Response to Request for Information – SSD 49295711 MOD 7 Harbourside Shopping Centre Redevelopment – Substation Plant

This letter has been prepared by Ethos Urban on behalf of Mirvac Retail Sub SPV Pty Ltd (Mircac) in response to the Request for Information received from the Department of Planning, Housing, and Infrastructure (DPHI) on 23 October 2025.

General Arrangement - L00 Ground Plan

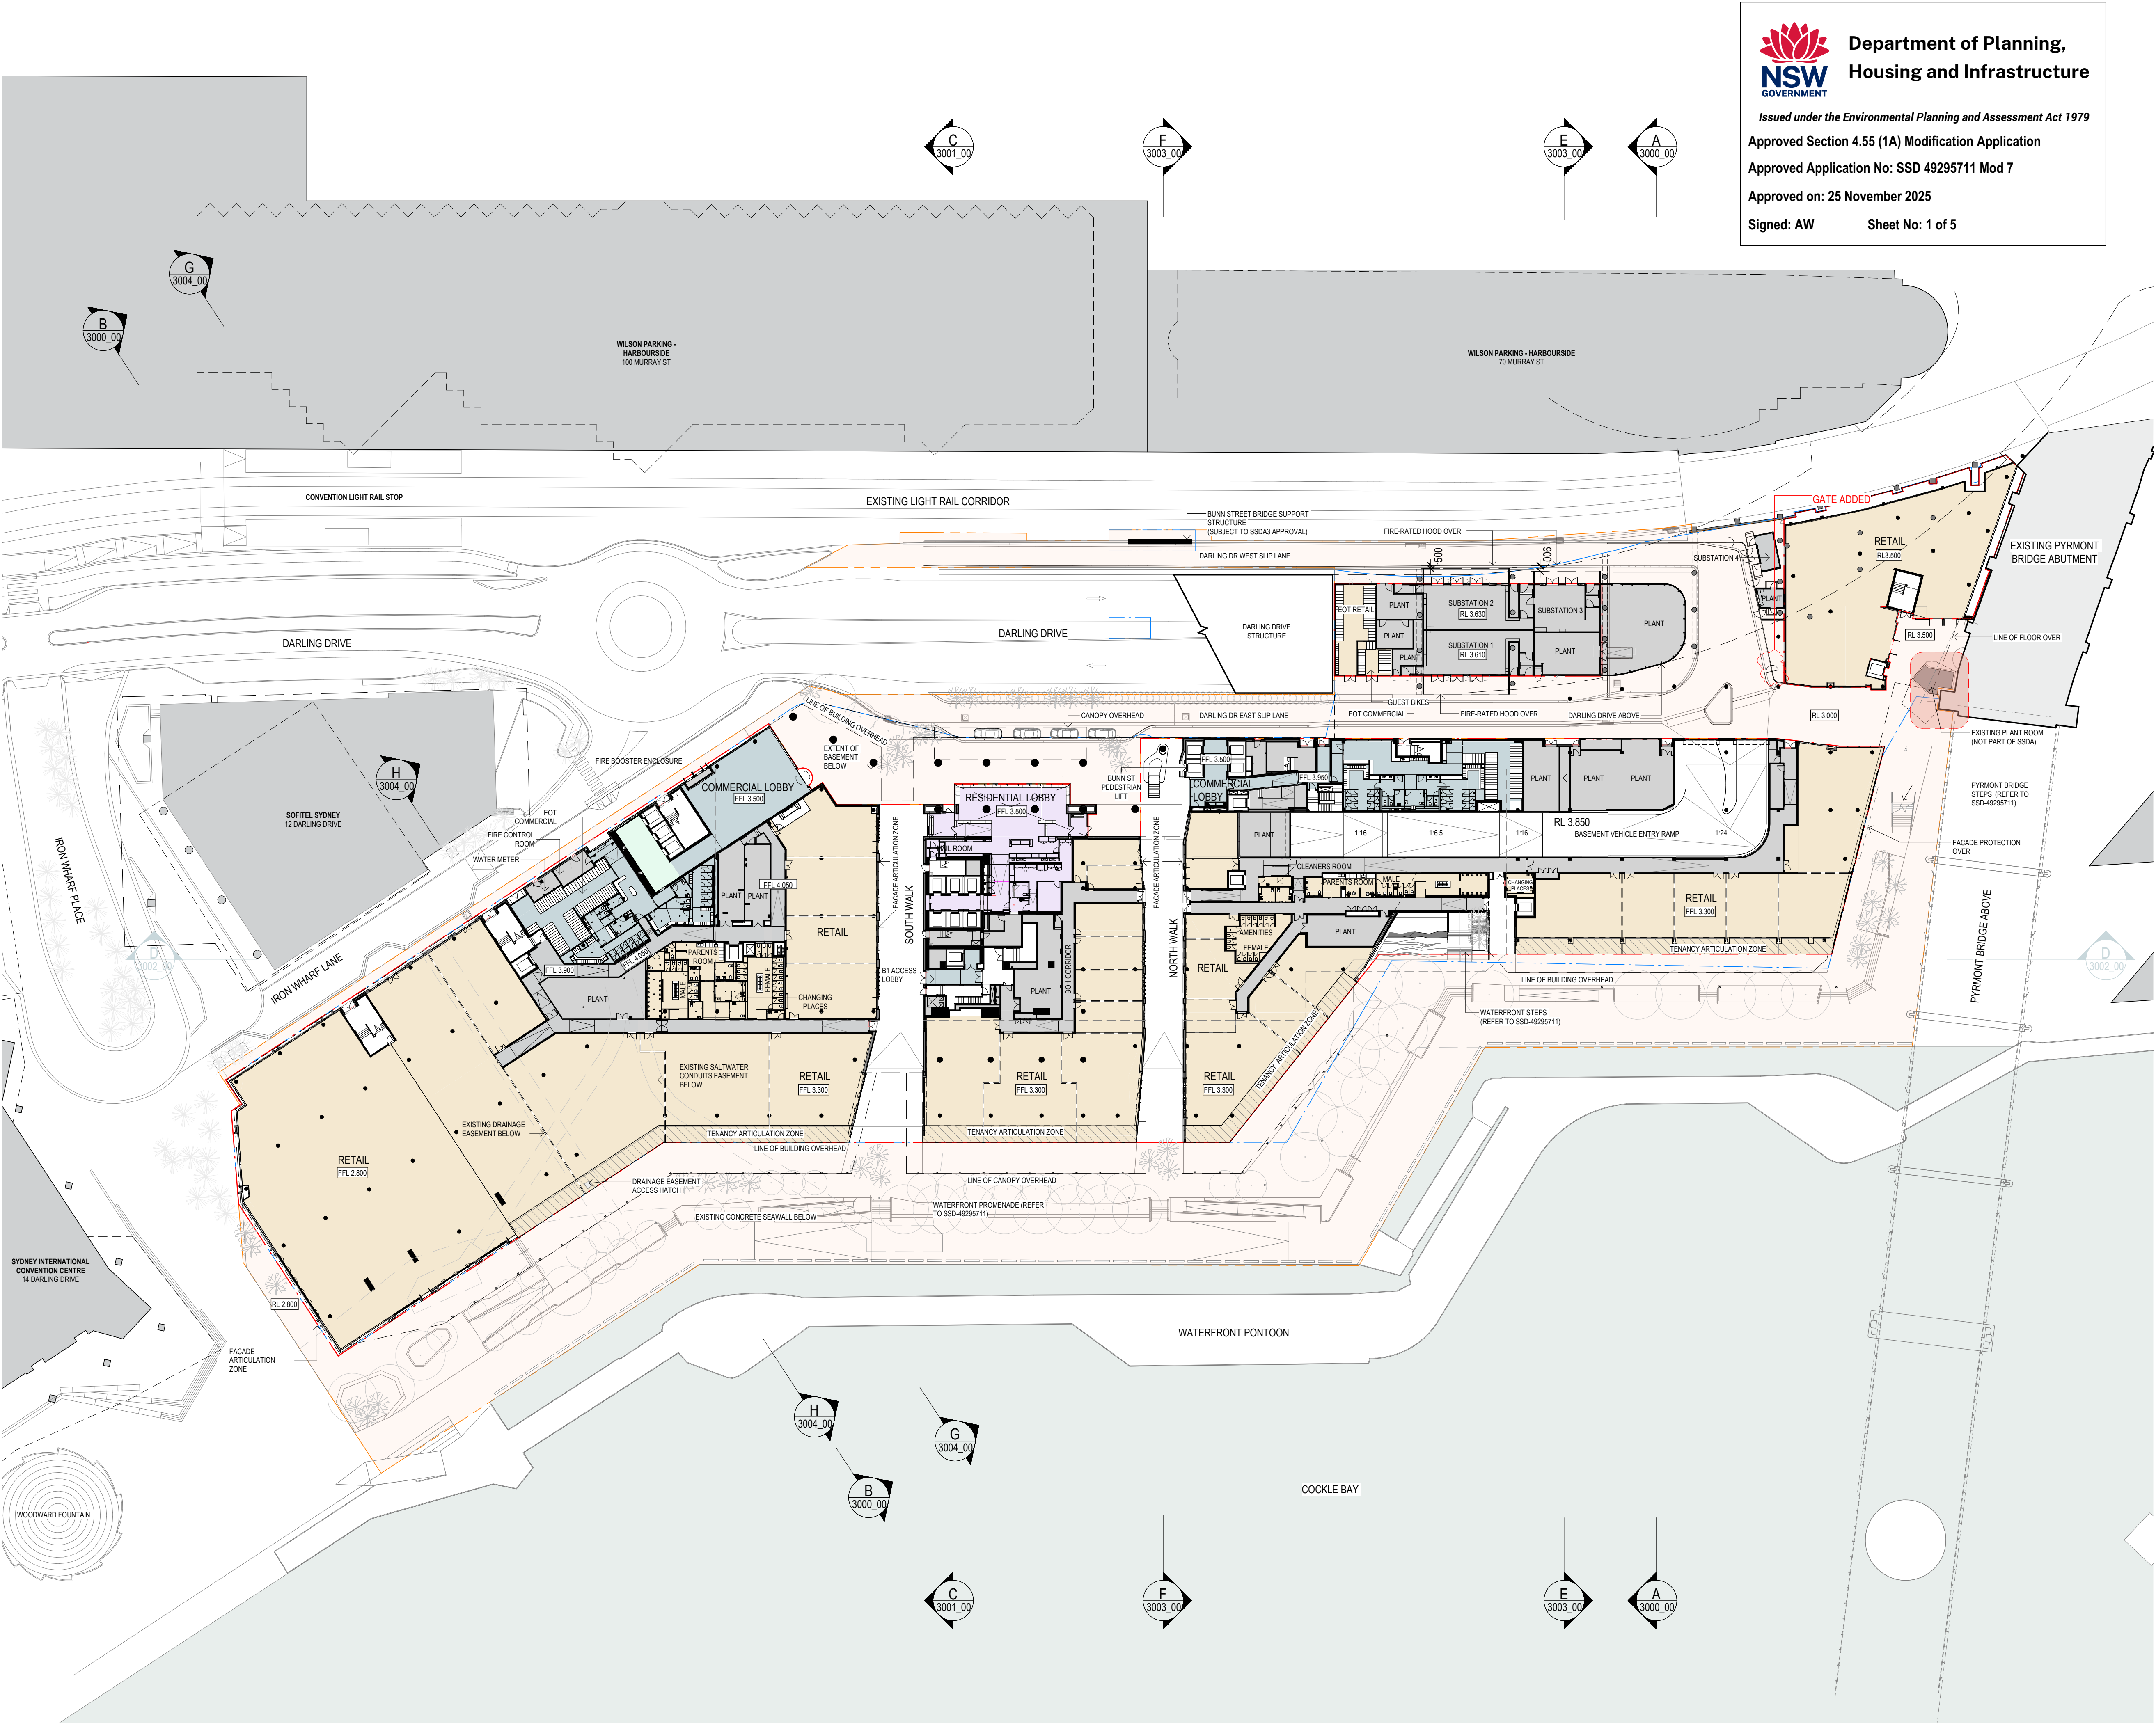
Amend the design of the fire hoods to enable pedestrian movements along both the west and east Darling Drive slip lane, noting the proposed hood walls would impede the public footpath and would require pedestrians to enter the road. The proposed design also creates concealment opportunities between Substation 2 and Substation 3's hood walls.

Amend the design of Substation 4's access doors to not open onto the public road.	The design of Substation 4's access doors has been amended so that they do not open onto the slip lane. See below comparison of lodged (left) and amended (right) configuration. An updated Ground Level Plan is provided at Attachment A showing the amended configuration.
---	---

Clarification should be sought as to whether a fire protection hood is required for Substation 4 and where it will be located. There is concern that where required, the hood may overhang the access road.

The proposed double swing doors to Substation 4 encroach into the roadway. It is suggested that doors opening into the roadway be limited/consolidated where possible. It is recommended a management strategy is developed for when doors are in operation.

Notwithstanding the above, the extent of the fire protection hoods for substation 2 and 3 has been minimised as much as possible, while still remaining compliant. The hoods now provide a clearance of 500mm in front of substation 2 and 900mm in front of substation 3 from the edge of the slip lane. This provides sufficient space for manoeuvring around the hoods without entering onto the road, if required, and also provides better sightlines and less opportunities for concealment. See below comparison of the as-lodged (left) and amended (right) design (also at **Attachment A**).

As detailed in the Substation Servicing and Access Statement at **Attachment C**, the Substation 4 design incorporates the required fire protection within the substation structure, including an integrated slab awning. It therefore does not require the same external hoods as Substations 1-3. Refer below for indicative section drawings of substation 4.

The design of Substation 4's access doors has been amended so that they do not open onto the slip lane. A comparison of the lodged and amended configuration is provided in the response to DPHI's Pedestrian Access and Servicing RFI in line 3 of this table.

An updated Ground Level Plan is provided at **Attachment A** showing the amended configuration.
